## KITTITAS COUNTY COMMUNITY DEVELOPMENT SERVICES

**RE: Sign Permit:** SI-13-00002 Wesco  
**Map Number:** 17-19-13052-0003  
**Parcel ID:** 596236

Your application for the placement of a sign at 691 Badger Pocket Road has been **approved** by Kittitas County Community Development Services as submitted subject to the conditions as stipulated by the comment letters from the Washington State Department of Transportation and the Kittitas County Fire Marshal (attached).

PROPOSAL #1401  
WESCO INTERNATIONAL

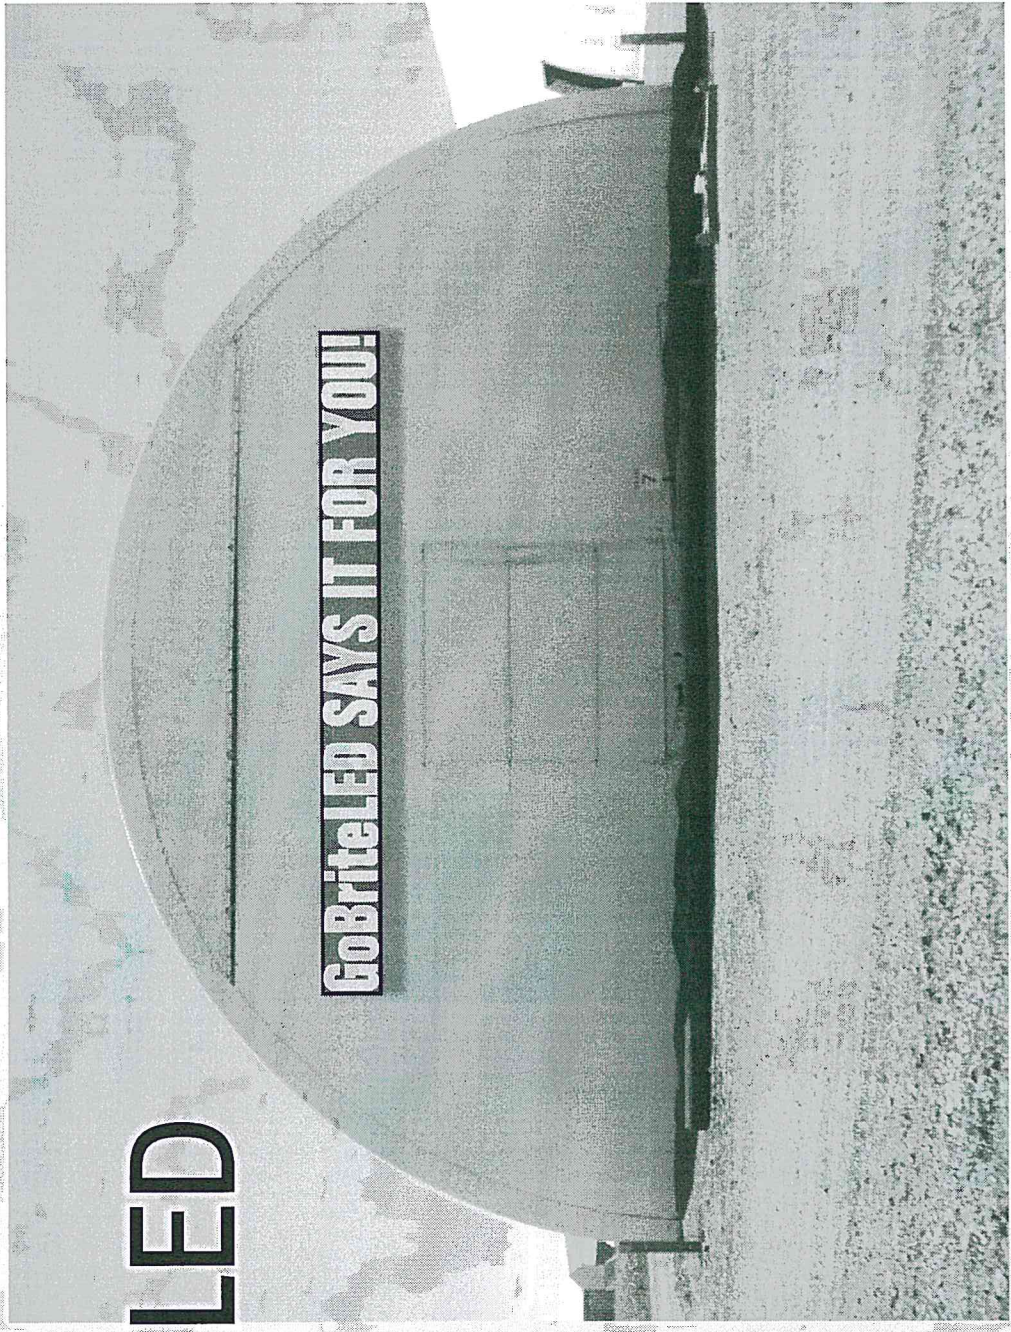
Now we've verified that the proposed sign is an electronic sign, here are rules for operating such signs as Type 3(a) on-premise signs visible to Interstate 90:

**WAC 468-66-050(3)(g)** Electronic signs may be used only as Type 3 on-premise signs and/or to present public service information, as follows:

- (i) Advertising messages on electronic signboards may contain words, phrases, sentences, symbols, trademarks, and logos. A single message or a message segment must have a static display time of at least two seconds after moving onto the signboard, with all segments of the total message to be displayed within ten seconds. A one-segment message may remain static on the signboard with no duration limit.

- (ii) Displays may travel horizontally or scroll vertically onto electronic signboards, but must hold in a static position for two seconds after completing the travel or scroll.

- (iii) Displays shall not appear to flash, undulate, or pulse, or portray explosions, fireworks, flashes of light, or blinking or chasing lights. Displays shall not appear to move toward or away from the viewer, expand or contract, bounce, rotate, spin, twist, or otherwise portray graphics or animation as it moves onto, is displayed on, or leaves the signboard.

- (iv) Electronic signs requiring more than four seconds to change from one single message display to another shall be turned off during the change interval.

- (v) No electronic sign lamp may be illuminated to a degree of brightness that is greater than necessary for adequate visibility. In no case may the brightness exceed 8,000 nits or equivalent candelas during daylight hours, or 1,000 nits or equivalent candelas between dusk and dawn. Signs found to be too bright shall be adjusted as directed by the department.

The intent of this regulation is to mitigate driver distraction. The most common violations we see on electronic signs are flashing and overboard use of graphics (spinning, pulsing, appearing to move toward/away, etc.). Advice here is to keep it simple; display the message for minimum two seconds, display next message, and so on.
